ROYAL RANDWICK RACECOURSE

ACCESS REVIEW

Morris-Goding Accessibility Consulting

21th September 2010

01 PARADE RING SECTION A-A

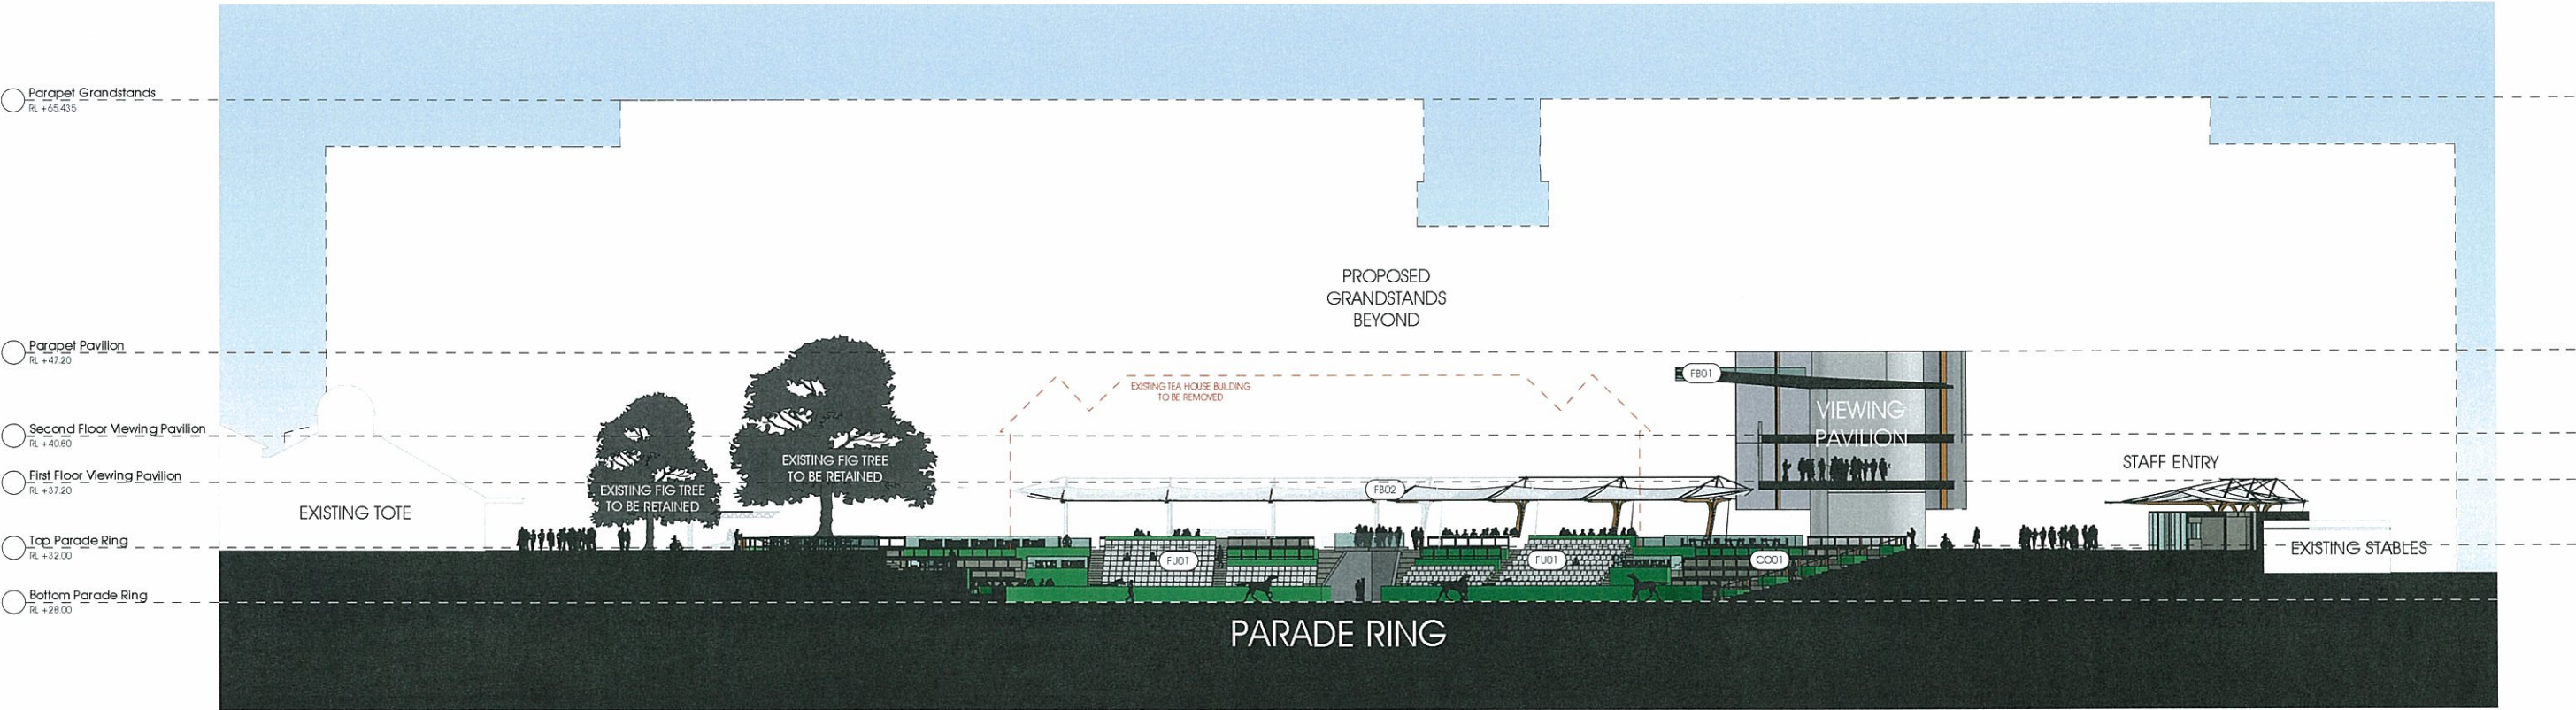
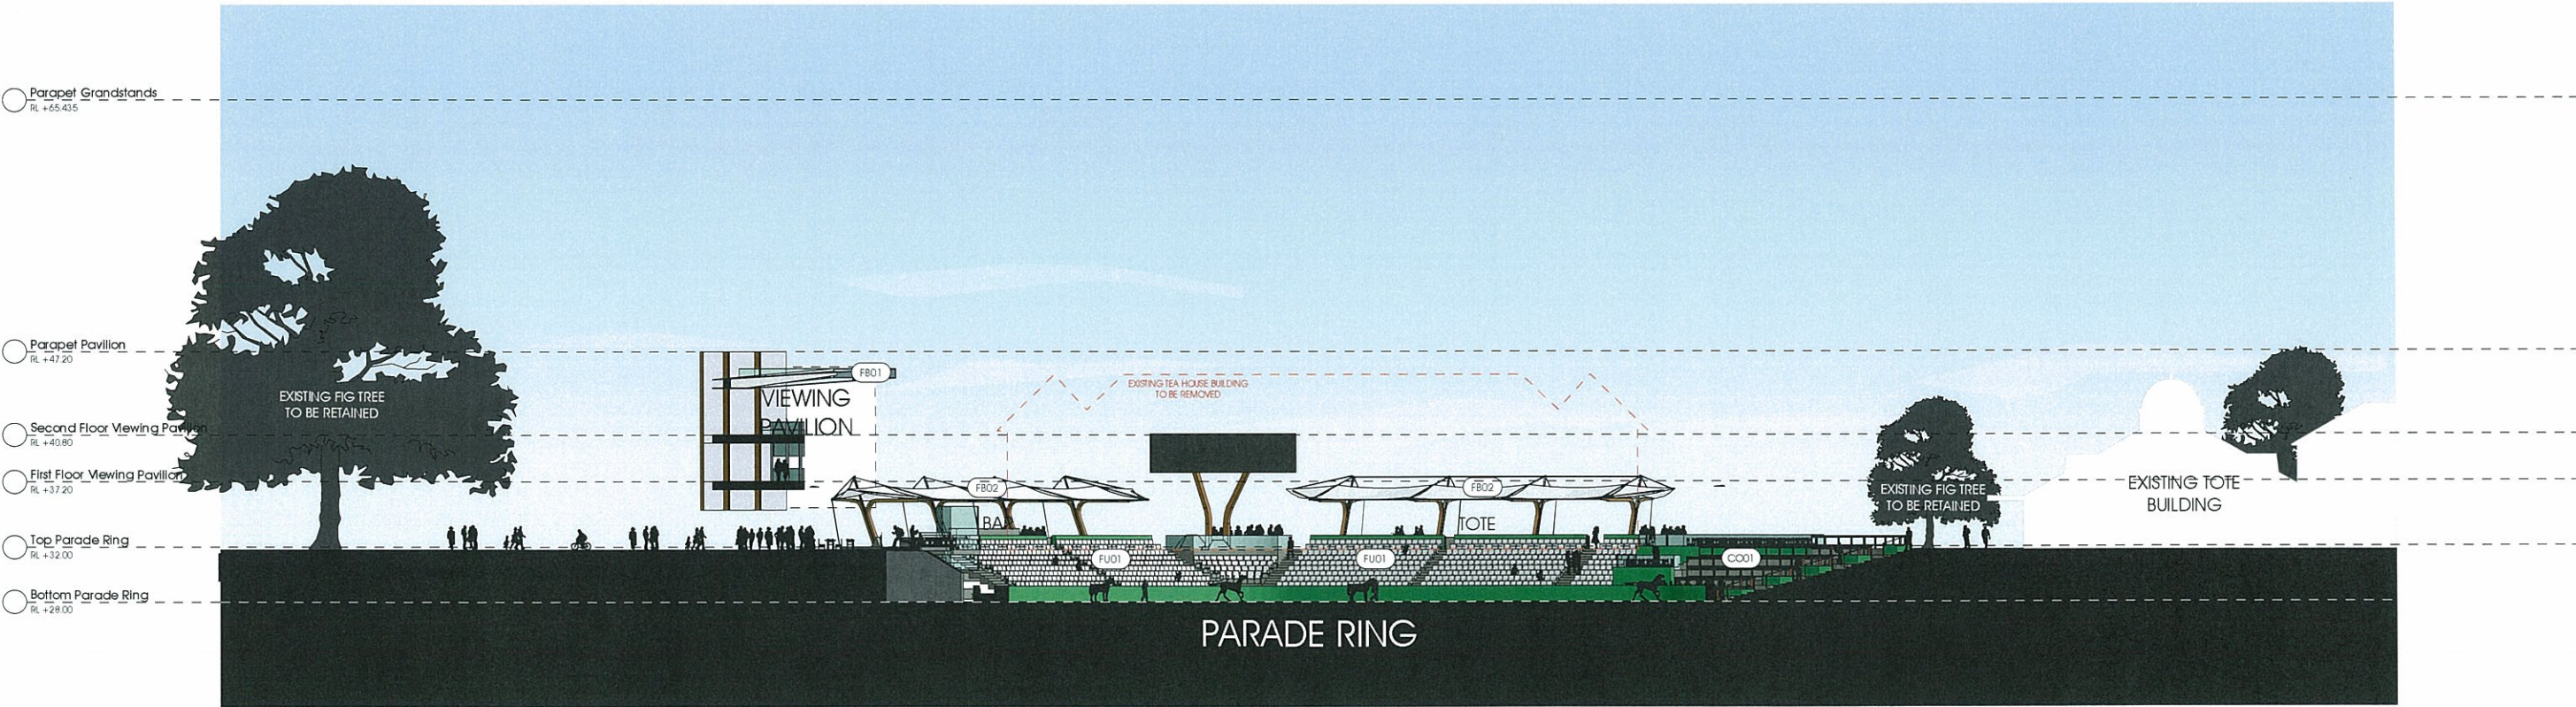
Currently there is tiered seating surrounding the Parade Ring. Access to these seating areas is possible only via stairs only. However, the drawings show 2 viewing platform appropriate for wheelchair users, in compliance with AS1428.1.

In addition, a ramp will be made available for wheelchair users to a lowered section along the raked seating area, compliant with the DDA Premises standards. Currently drawings do not show this detail. Detail comments regarding the design of this ramp will be made at the detailed designed stage.

- (i) Ensure floor systems used are slip resistant in accordance with AS4586 and HB197.
- (ii) Ensure the ramp has a gradient fall no steeper than 1:14, compliant with AS1428.1.
